re: **Geotechnical Review of Site Servicing Plans
Proposed Residential Development
5618 Hazeldean Road – Abbott’s Run – Block 13 – Ottawa, Ontario**

file: PG7640-MEMO.03 Revision 1

Paterson reviewed the following site servicing drawings set prepared by DSEL for the aforementioned development:

- Abbott’s Run Block 13 Site Plan - Project No. 1295_Block13, Sheet No. 1 to 19, Revision 2 dated October 24, 2025.

FIGURE 1

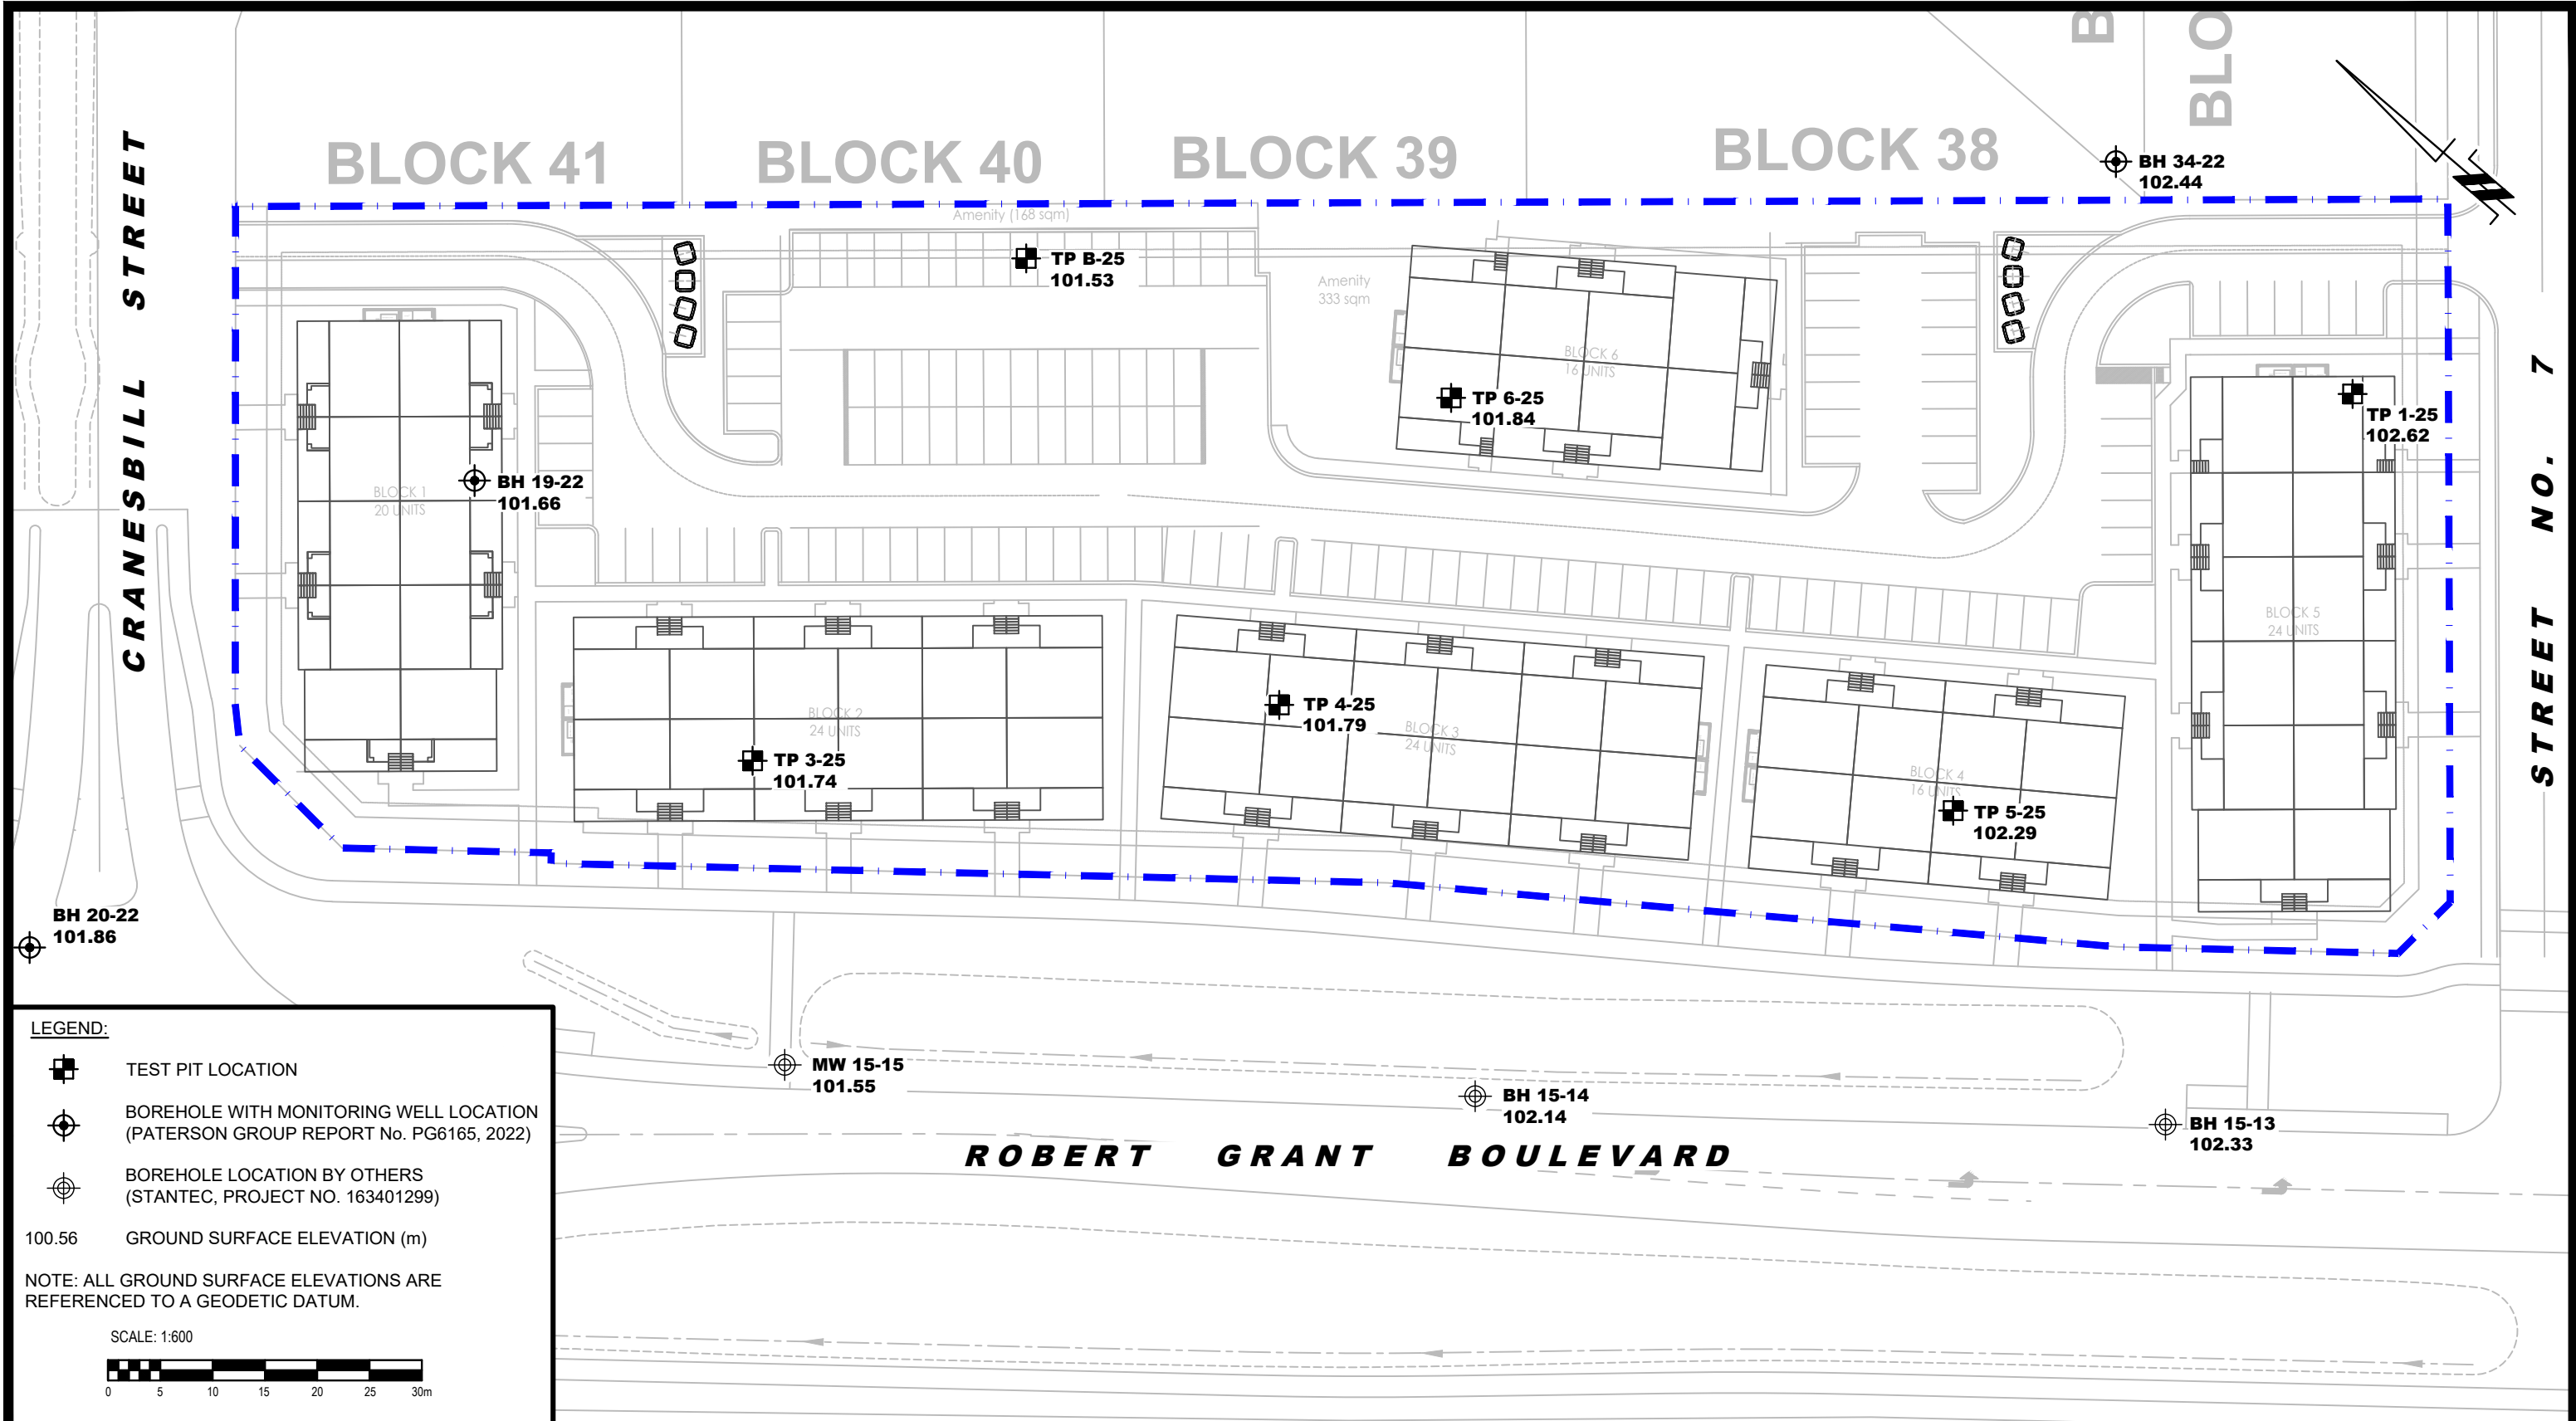
Paterson noted several areas in which underground services are proposed within the lateral zone of influence of the adjacent proposed buildings (i.e. within the plane extending 1 Horizontal:1 Vertical down and outwards from the edge of proposed footing). To ensure that the proposed services do not incur additional loading due to the adjacent proposed dwellings, and to permit future maintenance of the underground services without causing detrimental effects to the adjacent structures, Paterson has provided additional construction recommendations in subsequent sections of the present memorandum

It is recommended that the lateral zones of influence be lowered in the affected areas such that the influence plane (1H:1V) extending down and outwards from the edge of the proposed footings do not contain any underground services. This may be accomplished by extending the underside of footing (USF) for impacted strip footings to the elevations provided in Table 1 below.

Alternatively, this may be accomplished by casting a near-vertical lean-concrete (minimum 15 MPa, 28-day strength) in-filled trench extending between the design underside of footing elevation to the recommended elevations provided in Table 1 to a depth which would be unaffected by service trench works. The near vertical, zero-entry trench should extend horizontally a minimum 150 mm beyond the overlying footing faces. The zero entry, near-vertical trench sidewalls are intended to act as the formwork to cast the concrete. The bottom of the excavation should be reviewed by Paterson personnel prior to placing concrete. Once the trench excavation is approved by Paterson, lean concrete can be poured up to the design underside of footing elevation.

The extents of the trench running below a strip footing and adjacent to a site service pipe should be terminated by extending the trench upwards and back up to the design underside of footing elevation at an incline of 1H:2V along the opposite oriented-running strip footings. Reference should be made to the attached Figure 1 – Recommended Lateral Zone of Influence Protection Areas for approximate locations in which the above-noted recommendations should be carried out.
